Subject: P/117/21/PL - Sefter Farm, Pagham Road, Pagham, PO21 3PX - FAO Simon Davis

**Developments Affecting Trunk Roads and Special Roads
Highways England Planning Response (HEHR 2021)
Holding Recommendation in connection with an
Application for Planning Permission**

Council's Reference: P/117/21/PL

Proposal: Construction of a new packhouse including relocation of staff parking area and landscaping. This site may affect the setting of a listed building and is in CIL Zone 5 (Zero Rated) as other development.

Figure 3.1 – Architect's illustrative site layout

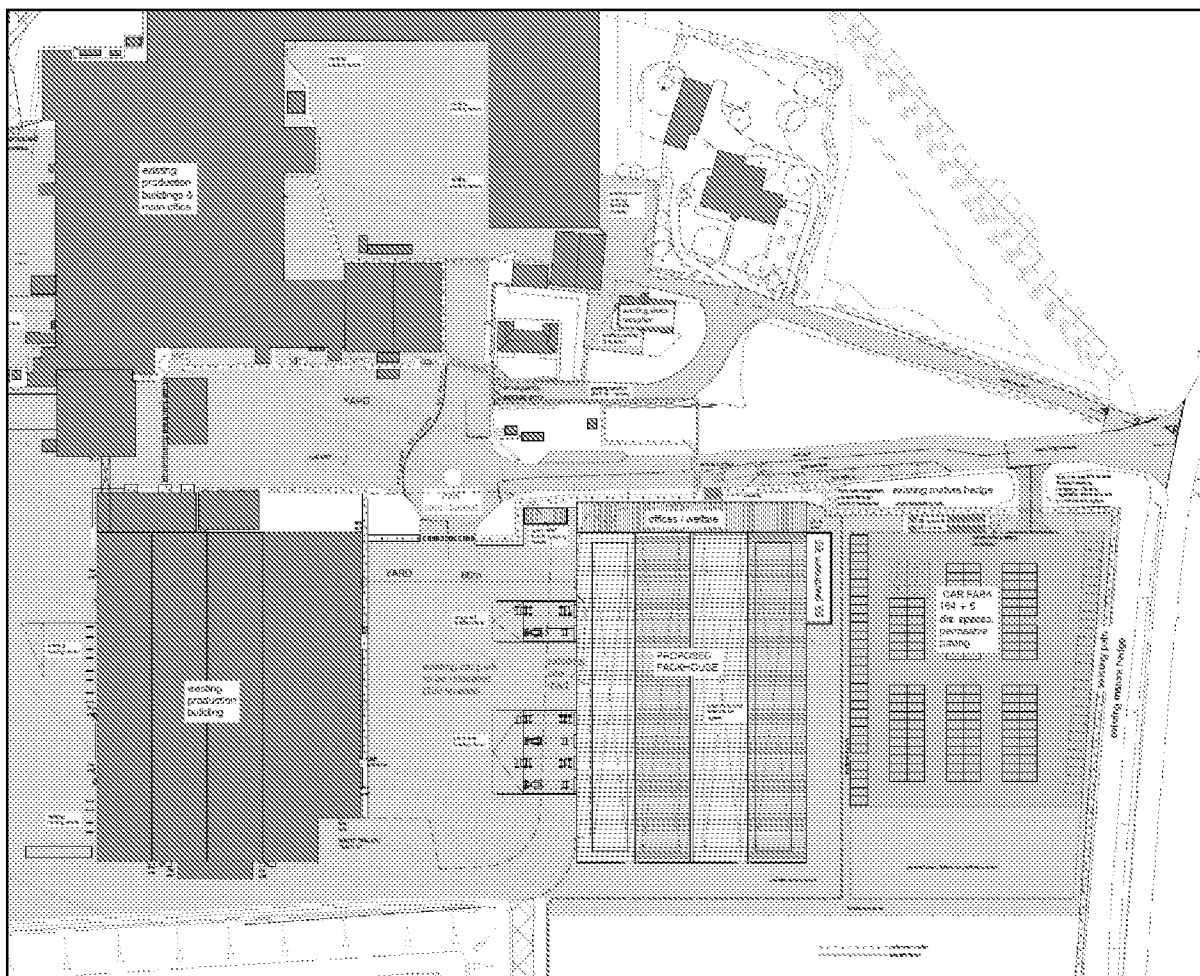
The car park relocation requires the existing 219 spaces to be moved to the east of the new packhouse unit. While the TS states that there will be no increase to staff and no new trips forecasted, this has not been demonstrated given the proposal should be considered as a new B2/B8 unit. However, Arun District Council's parking standards dictate that one parking space is required per 100sqm. The development comprises

6,430sqm and, therefore, this equates to 64 spaces; land for which will be safeguarded to the south of the new parking area location.

If it is intended that the 64 spaces not be provided, a car parking accumulation study should be carried out to confirm that the 219 spaces can adequately accommodate the forecast traffic generation from the proposed land use without the need for the additional 64 spaces.

ACTION: A car parking accumulation exercise is required to be included in the revised Transport Statement
